Ribble Valley Borough Council  
Housing & Development Control

Application no: **3/2022/0500**

Address: **Land to the south of Chatburn Old Road Chatburn**

Proposal: **Technical Details Consent for residential development of upto 9 dwellings following Permission in Principle application 3/2018/0582 and appeal APP/T2350/W/19/3223816.**

PL 30

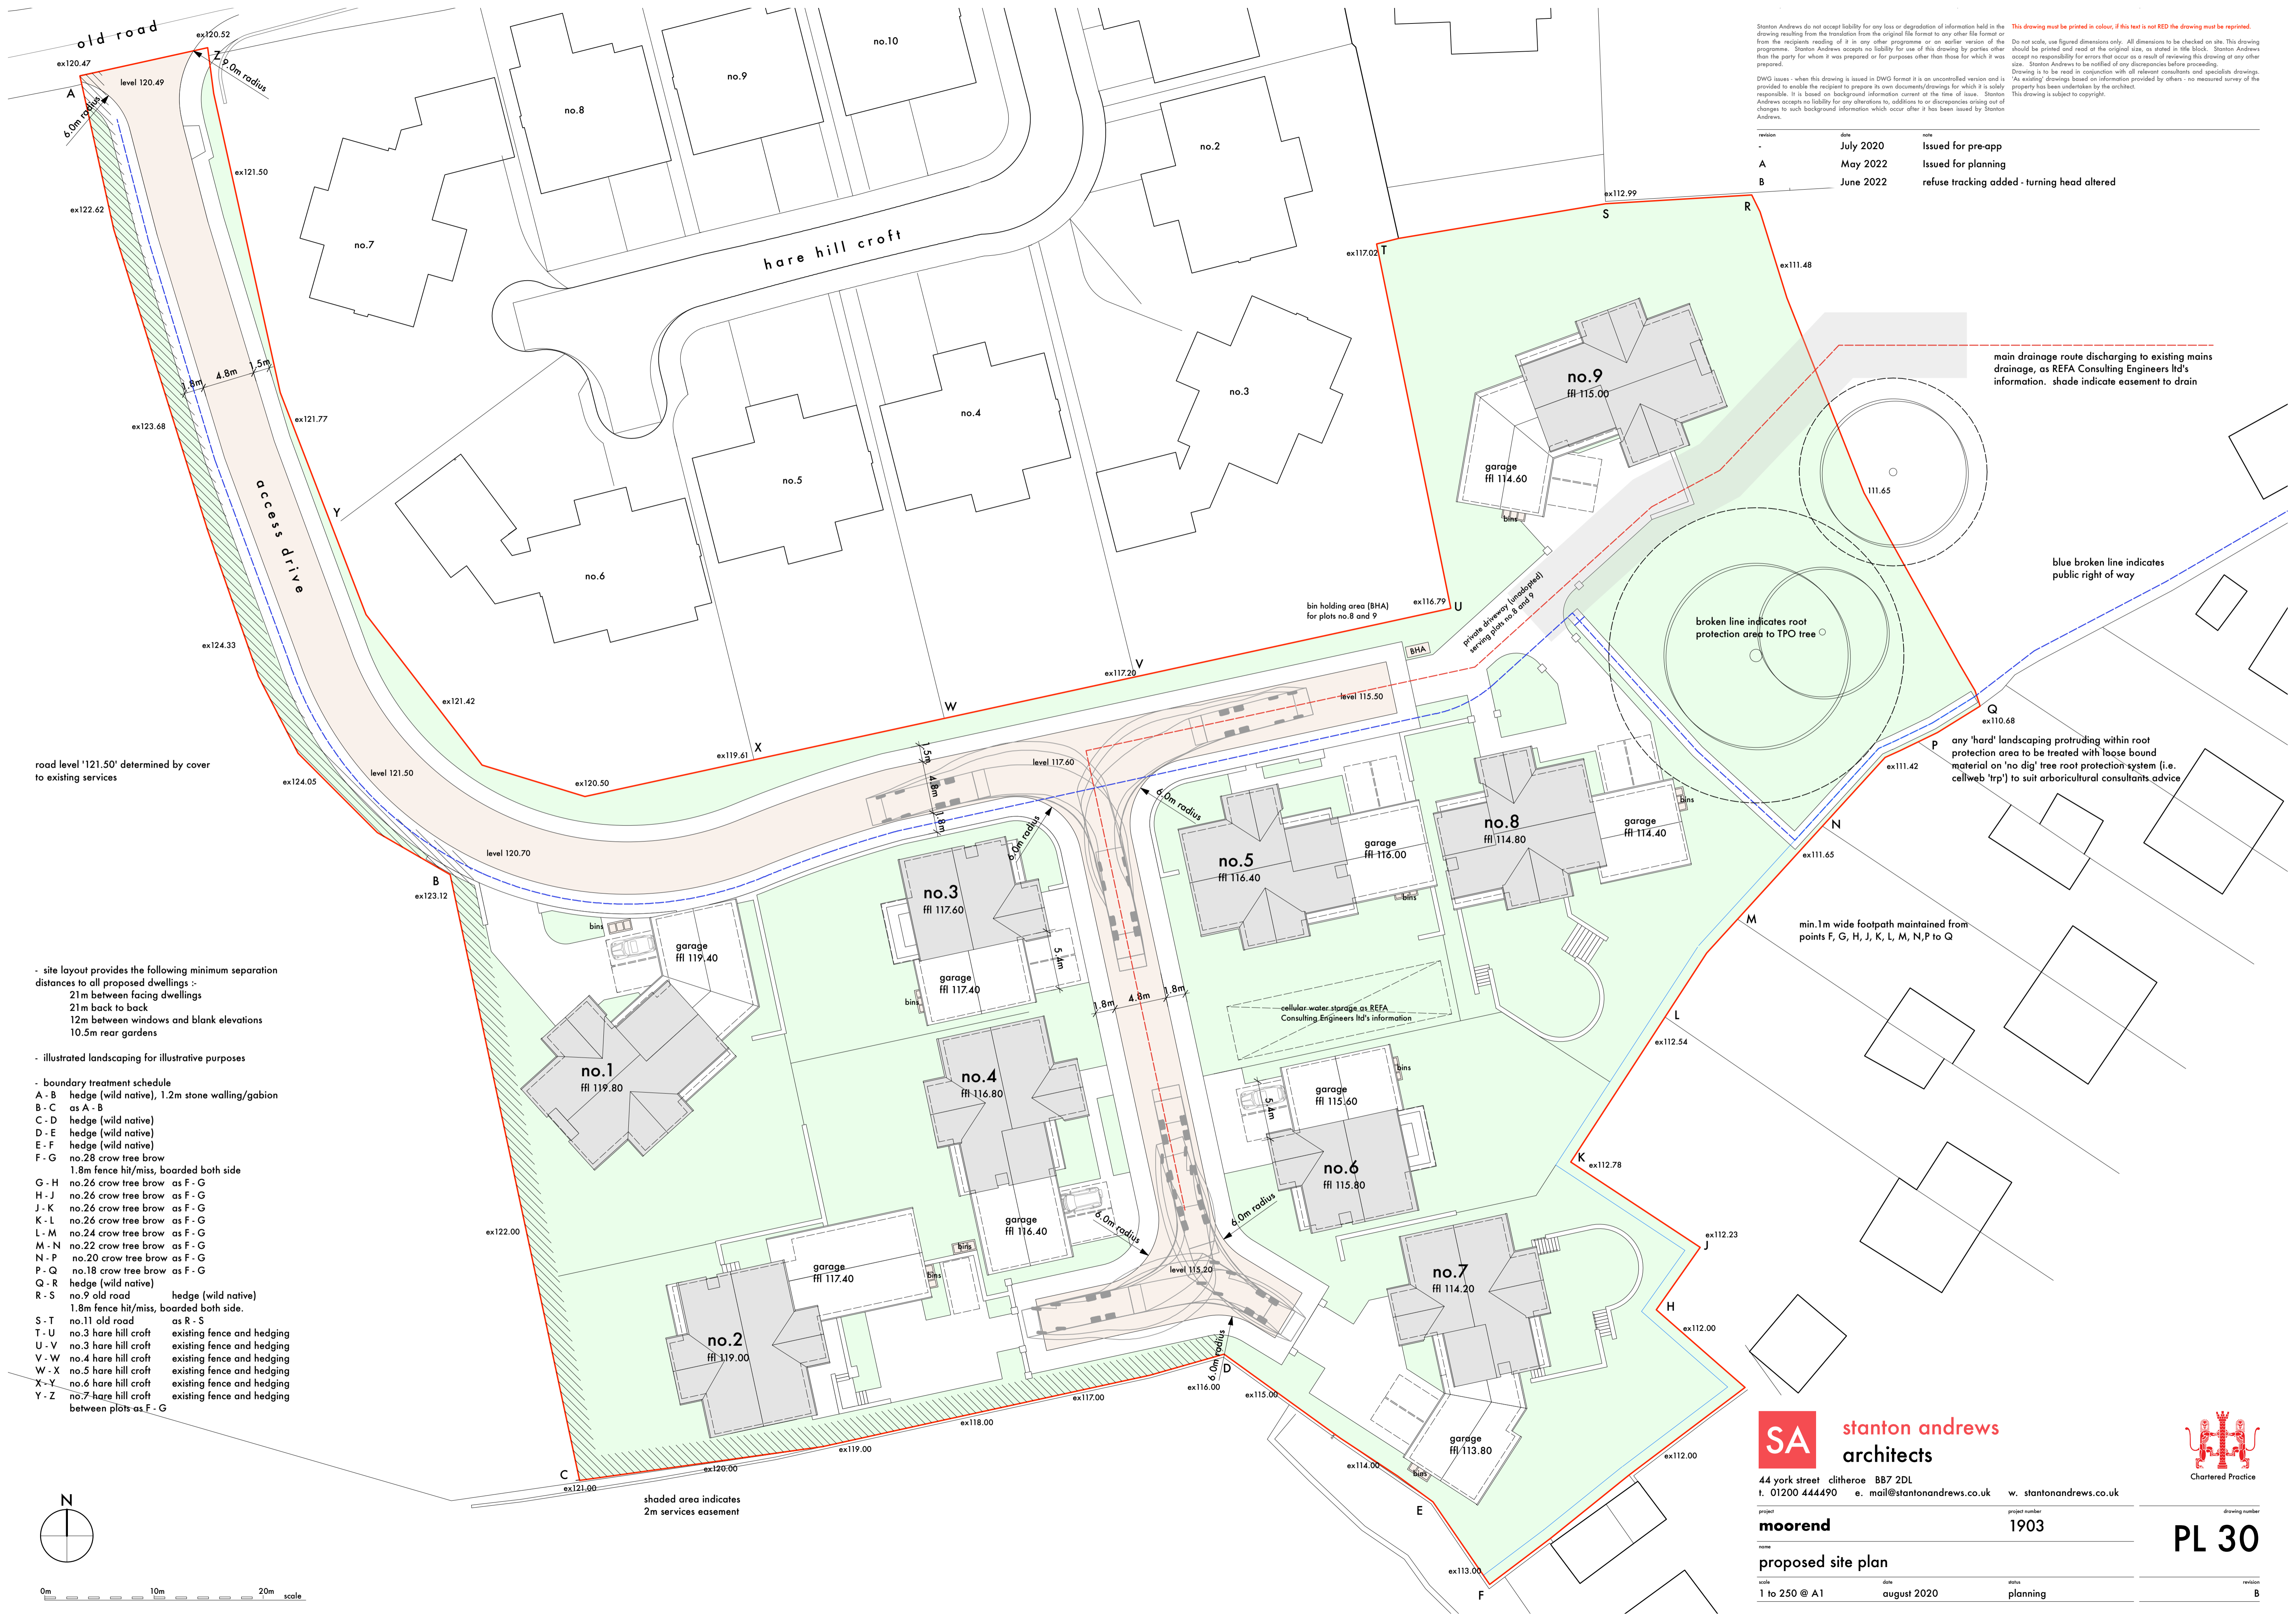
The LHA have reviewed Stanton Andrews drawing number PL30 Rev C titled "Proposed Site Plan" and are aware that the proposed access will have kerb radii's of 6m and 8m, while the access width will be approximately 8.6m wide which reduces to 4.8m at a distance of 8.5m from the public highway. At the access, the site will also provide 2m wide footways on either side.

In any case, the LHA have studied Stanton Andrews drawing number PL30 Rev C titled "Proposed Site Plan", which details the full site layout and require further amendments to be made to make the internal layout safe. This is because of the following, which will be discussed below.

Even though the site will not be adopted, the LHA still require the spine road of the internal carriageway to be 5.5m wide. The LHA will accept that the footway to the right of the access which measures 1.3m wide can be reduced to 0.5m to enable the carriageway to be widened to the required width, granted that the other footway remains 2m wide to serve the dwellings and Public Footpath 3-11-FP1.

The LHA will, however, accept the junction which serves Plot 2-7 to remain 4.8m wide with 1.8m wide footways either side.

The LHA also require the turning head provided adjacent to Plot 2 to be amended. This is because as shown on Stanton Andrews drawing number PL30 Rev C titled "Proposed Site Plan," a swept path of an HGV using the turning head is shown. The concern that the LHA have is when the HGV is using the turning head the body of the HGV overlaps the footway adjacent to Plot 2 when attempting to exit the site in a forward gear. The wheels of the HGV in this location are also extremely close to the footway. Therefore, the LHA require the turning head to be extended in size and that an amended swept path of a refuse vehicle this time, is provided to ensure that the size of the turning head is adequate.

The LHA require the private access track serving Plots 8 and 9 to provide an access track measuring a minimum of 4.25m wide for the duration of its length. The track should also be adequately surfaced.

The LHA also require a boundary treatment drawing to be submitted. This is because the LHA are aware that the embankment to the left of the access may require a retaining wall feature to be erected due to the level difference of the internal carriageway and the embankment. Therefore, the LHA require further information as to whether a retaining structure will be erected in this location.

As a result of these concerns, the LHA require on a revised plan the access to be extended and the kerb radii to be increased to 10m on both sides of the access to help with the turning movements of vehicles into and out of the site.

The LHA suggest that the access is widened by a minimum of 0.5m and the LHA will accept that the access is extended by reducing the width of the footway to the right of the access.

To ensure that the amended width and the kerb radii of the access is acceptable, the LHA will require a revised swept path drawing to be provided. The swept path should also show the refuse vehicle using the spine road into and out of the site to ensure the width of the internal carriageway is adequate.

The swept path drawing, as mentioned in the Site Access section, should also show the refuse vehicle using the full internal layout to ensure that the internal carriageway is adequate for its use.
